Kings Park Metal Recovery and Recycling Facility Expansion (SSD-10396)
Request for additional information

I refer to the Response to Submissions (RTS) for the Kings Park Metal Recovery and Recycling Facility Expansion (SSD-10396). The Department has reviewed the document and notes there continue to be outstanding matters that need to be addressed.

Attachment 1 – Department's comments

Attachment 2 – Noise – Department's comments

Figure 3 – Operational noise contours for shoulder period during calm conditions, L_{Aeq} , 15min

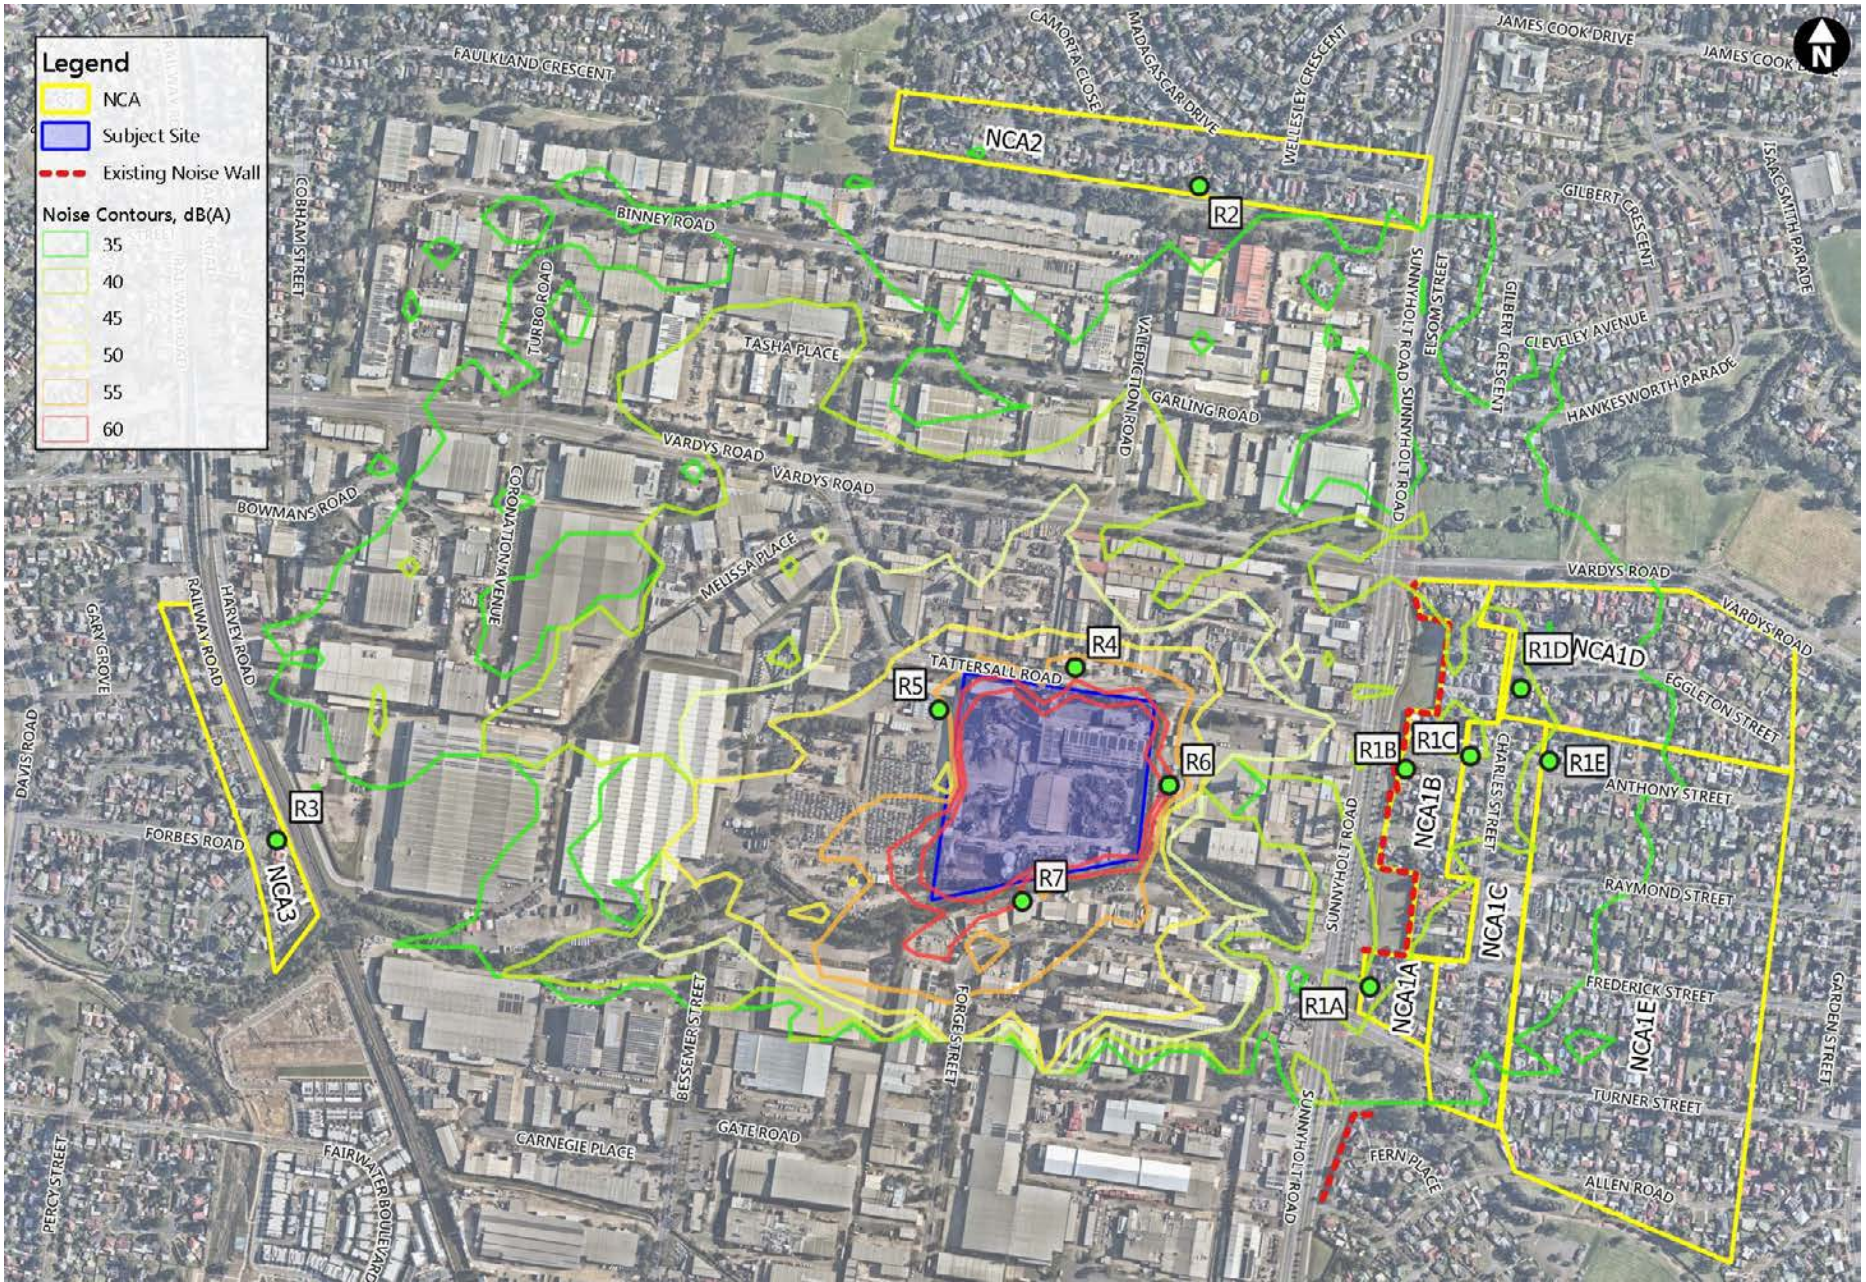
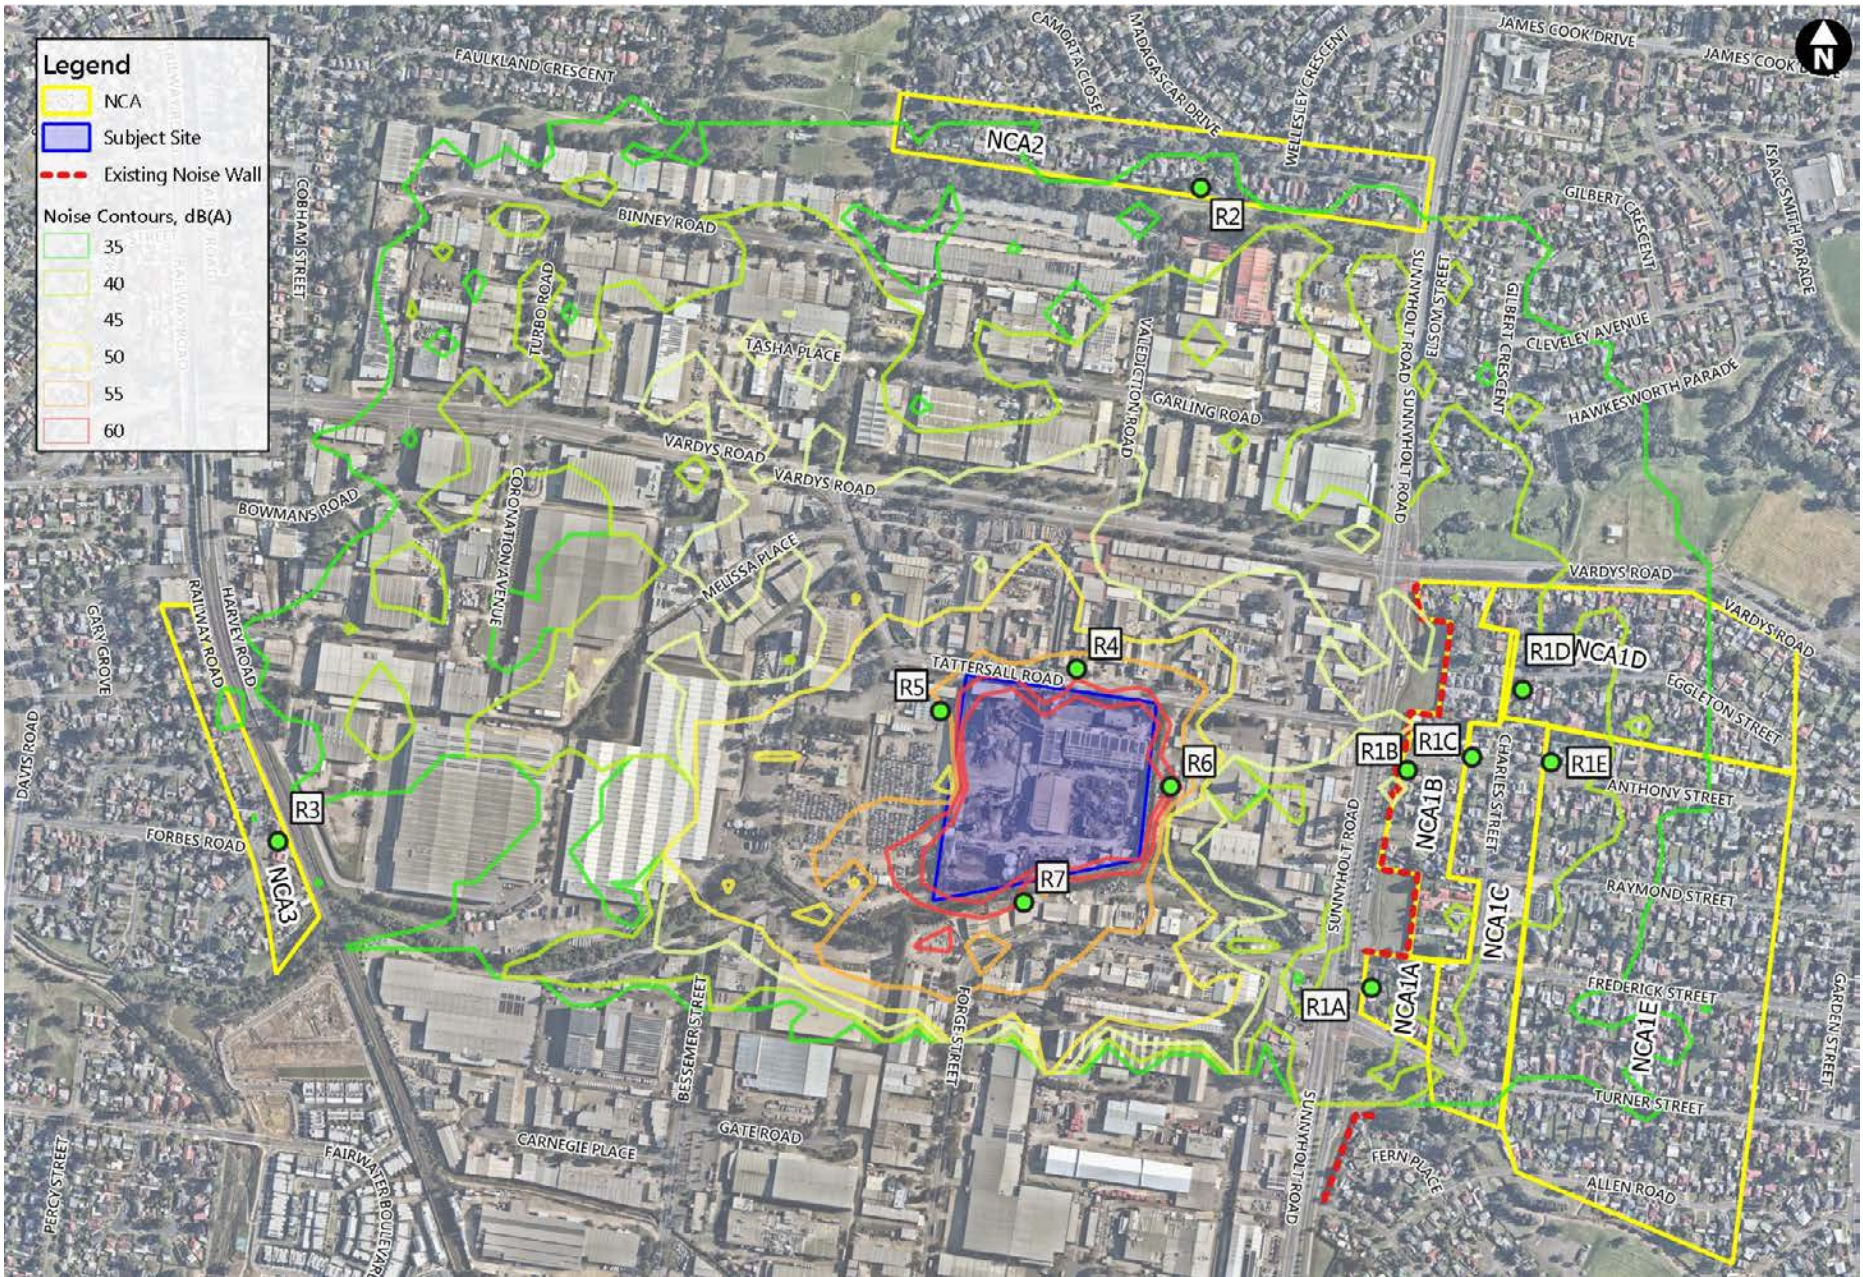
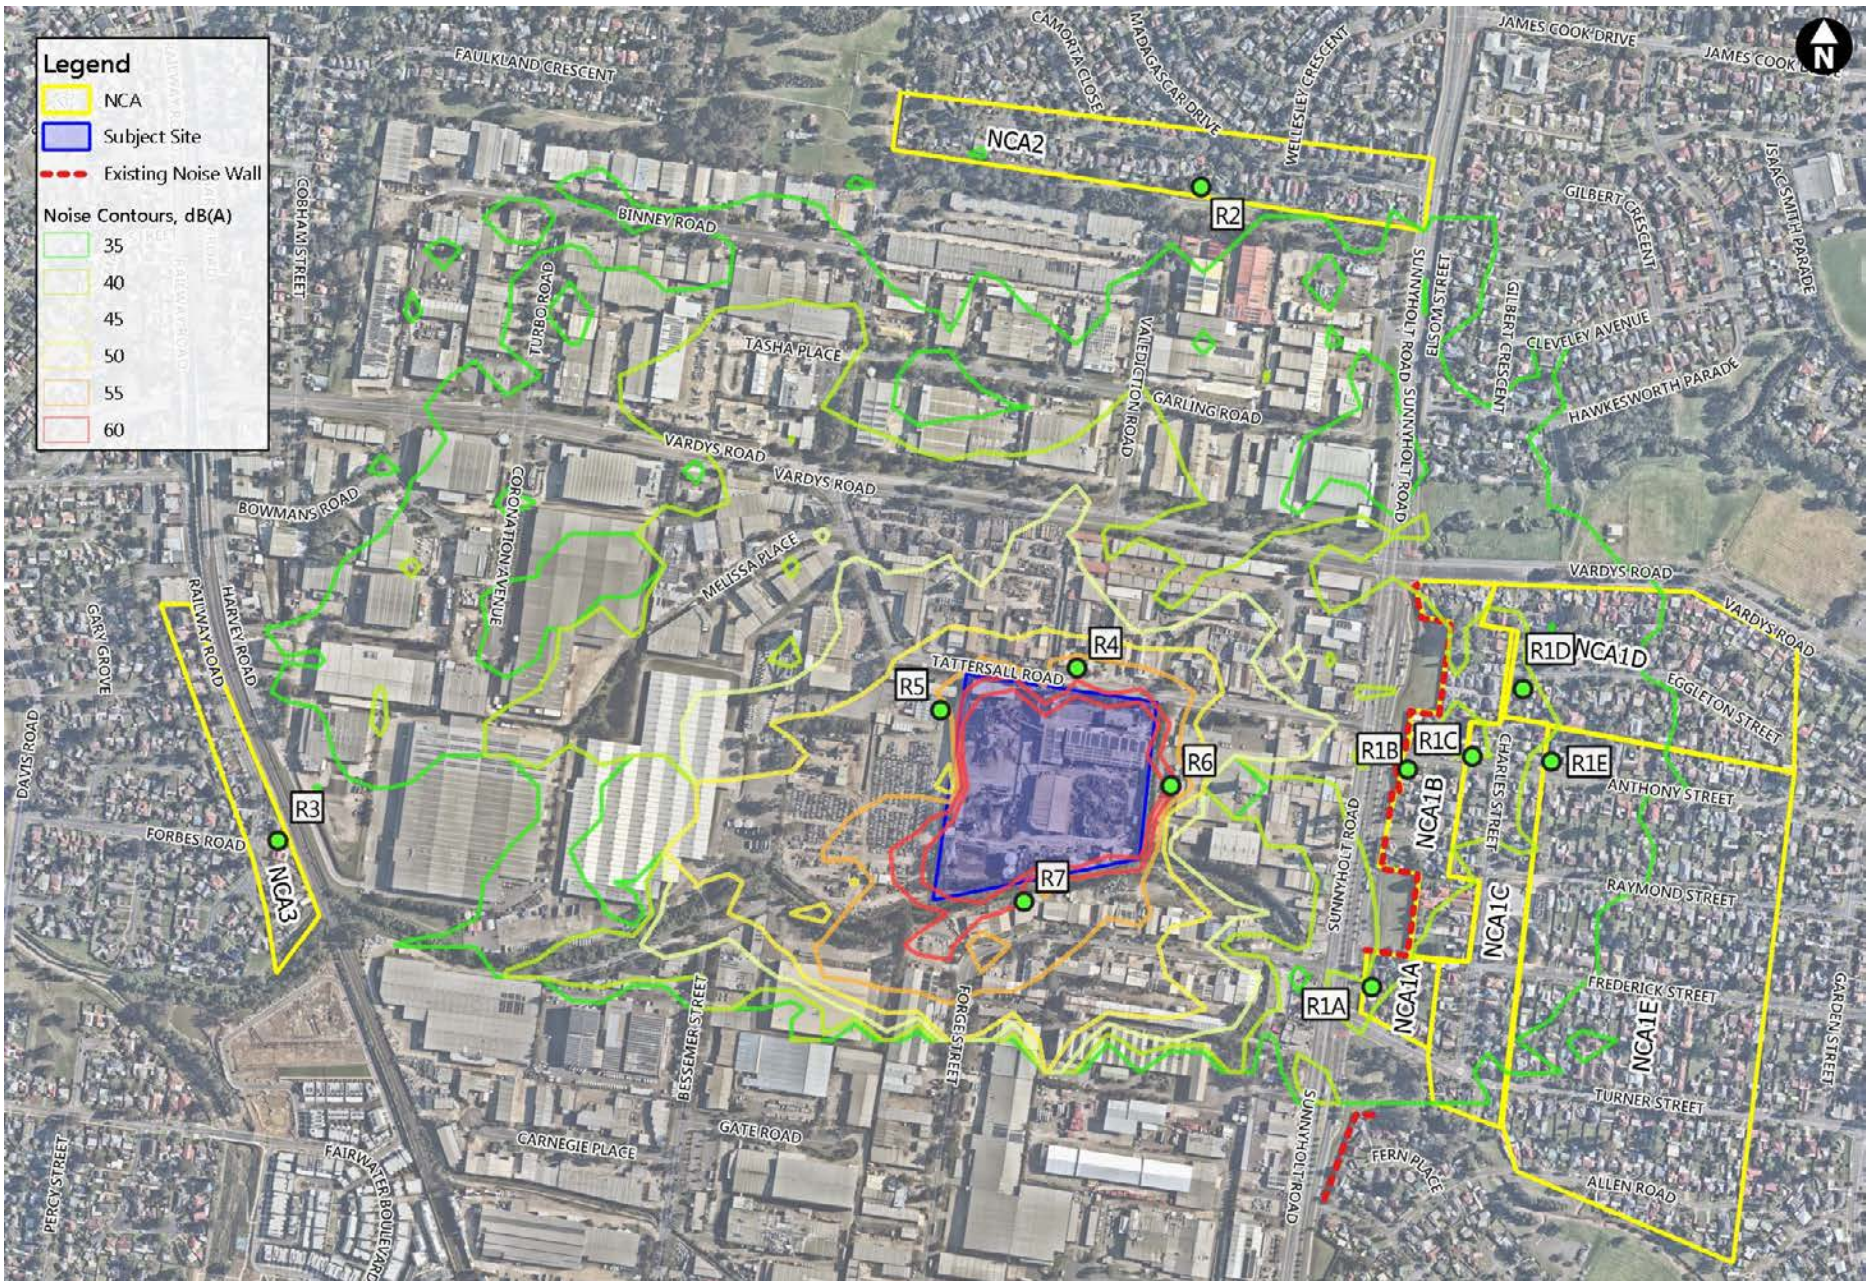
The Department requires additional background noise monitoring data be provided at a representative location along Anthony Street, east of 16 Anthony Street, Blacktown. In addition, operational noise contours must be updated to include all residential receivers from Sunnyholt Road to the highest location above sea level along Anthony Street, covering an assessment radius of no less than 700 metres from the eastern site boundary.

2. Operational noise survey and modelling
- Noise contours shall be updated to display a single decibel value instead of a range of decibel values for each contour line (see **Figure 1**).
